5 Government submissions

HVO South Modification 5

Response to submissions

Figure 3.2

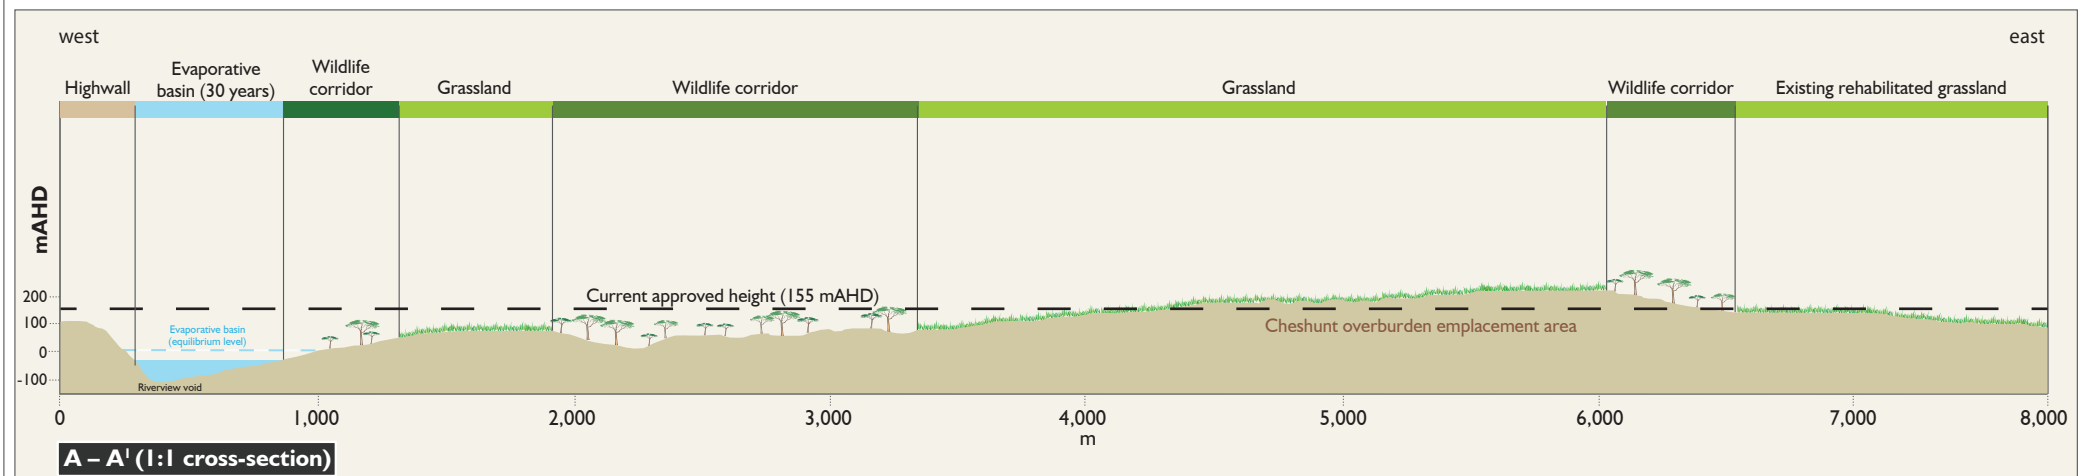
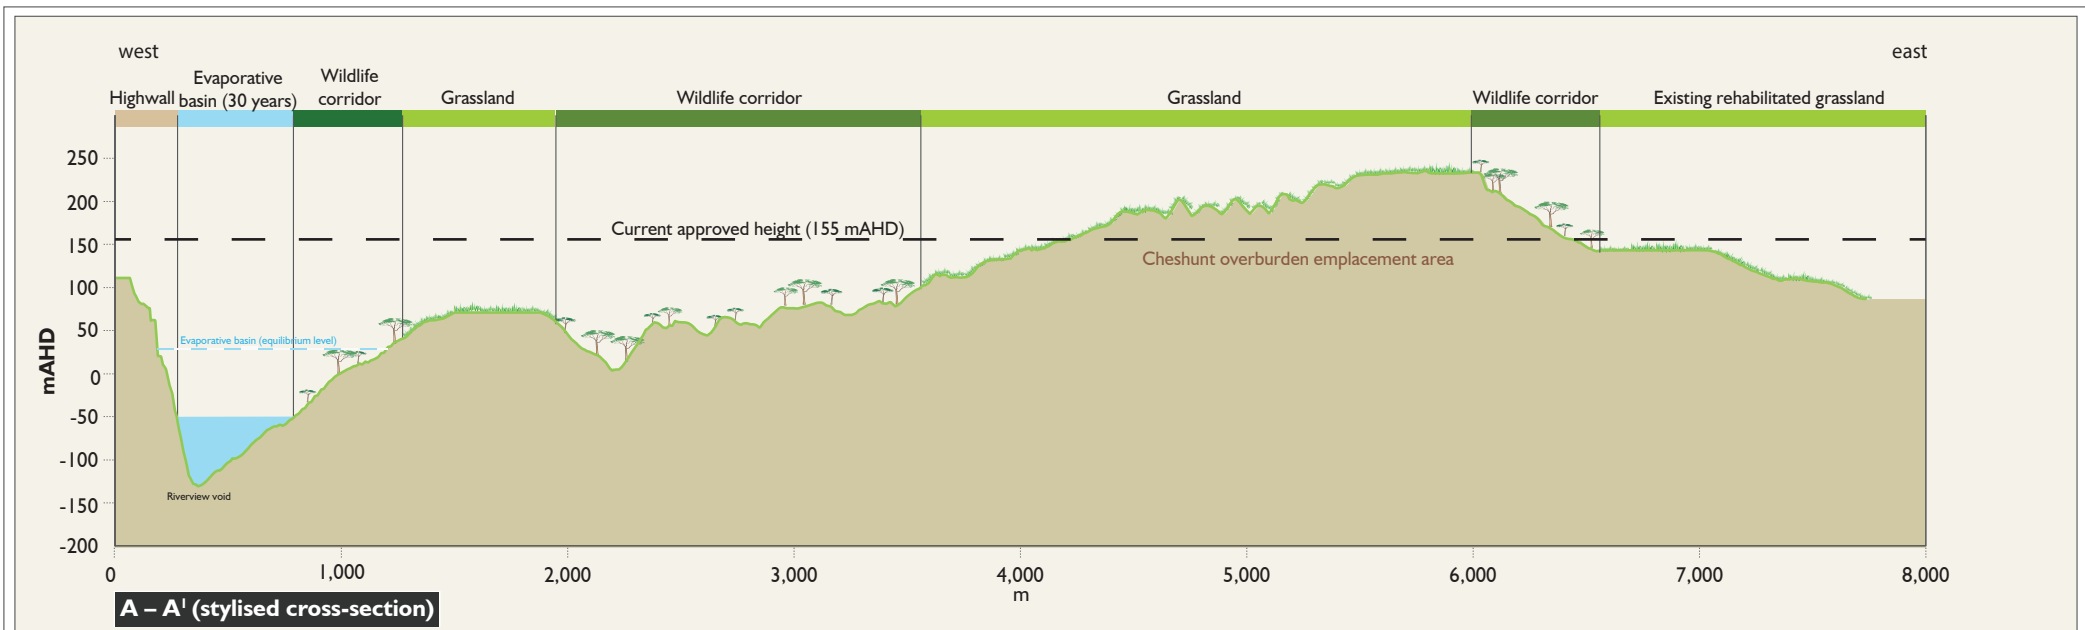
The DPE noted that the proposed design of the overburden emplacement area represents a substantial improvement to the traditional design and methods. The submission requested that Coal & Allied consider opportunities for further refinements, such as incorporating more topographic variation to the external slopes of the emplacement areas to improve visual amenity. DPE stated that the northern area of the Cheshunt overburden emplacement area appeared to have minimal macro-relief and may represent an opportunity for further refinement.

The DPE submission considered that additional material could be directed to reducing the final void or improving its shape and/or slopes. The DPE noted that whilst the final void is further away from the Hunter River, with a smaller surface water catchment, gentler low-wall slopes and more useable surface area, these improvements did not extend to the final highwall.

The submission stated the final slope appeared to be significantly steeper with the southwest corner at almost 90 degrees and requested the Coal & Allied consider further refinements to make the highwall less angular and more natural in shape. DPE also requested further information on the long term stability and safety of this final highwall design.

In response to the DPE request, Figure 3.3 of this RTS has been prepared to illustrate the stylised macro-relief at a 1:1 scale. Figure 5.2 has been prepared at a finer scale to assist with visualising the topographical relief in the northern area of the Cheshunt overburden emplacement area.

Figure 3.3 has been developed to show a 1:1 cross-section of the final void to assist in visualising the micro-relief context and slope angles afforded to the low-wall at scale, as well as the highwall's slope angle and its height/depth in context to landform within the overall disturbance footprint.

The highwall for the proposed modification is proposed to have an overall slope angle of between 35 to 42 degrees with a maximum individual slope angle of 75 degrees. This is consistent with the current approved final landform.
